Eagles Nest Wellness Center Greenhouses, PPR-17-049

Please accept the following comments from El Paso County Public Health regarding the project referenced above:

IMPROVEMENT SURVEY

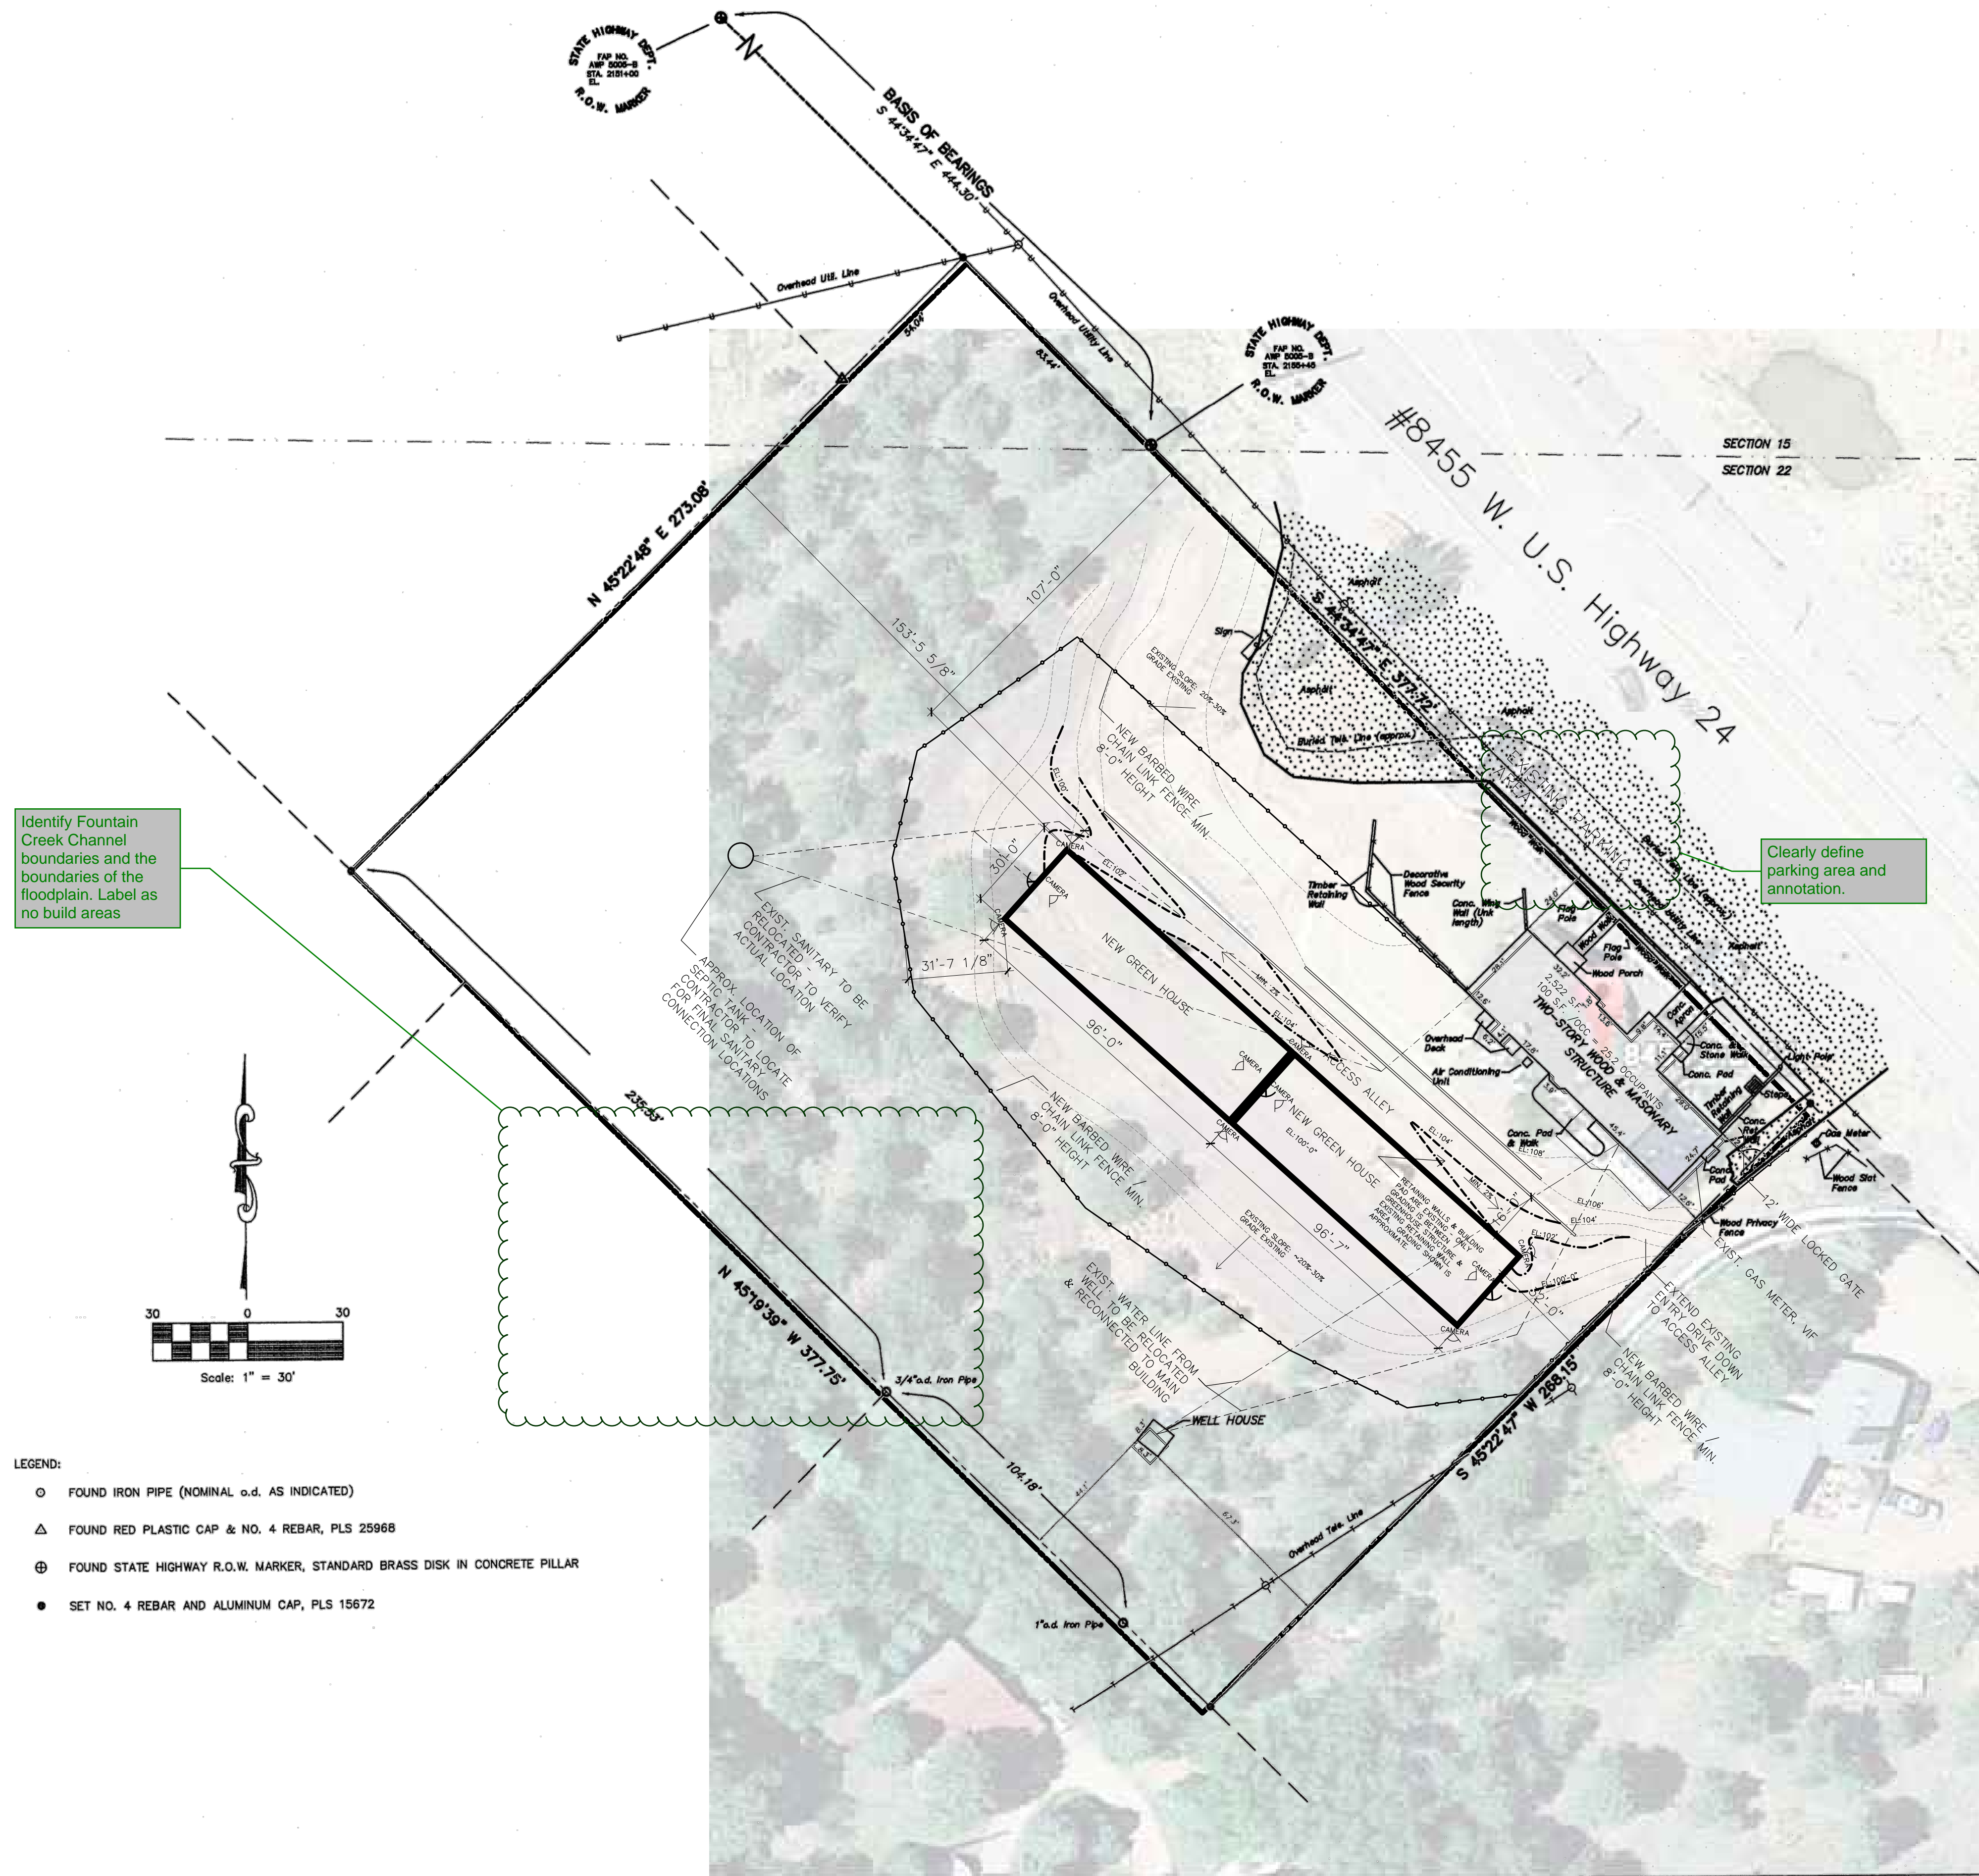
- Water service for the two proposed greenhouses is by an existing individual well.
- Wastewater service for the project is provided by an existing onsite wastewater treatment system (OWTS) that was installed in 1967 for an existing house. The Site Development Plan submitted shows an approximate location of the existing septic tank that does not correspond with the permitted OWTS component locations. Therefore, prior to any construction or any onsite grading, all components (septic tank, building sewer lines, and the soil treatment area) must be located. Measures must be taken to protect all the OWTS components from damage by construction vehicles and construction activities.
- An OWTS Minor Repair Permit is required, if necessary, for the relocation of any portion of the building sewer lines.
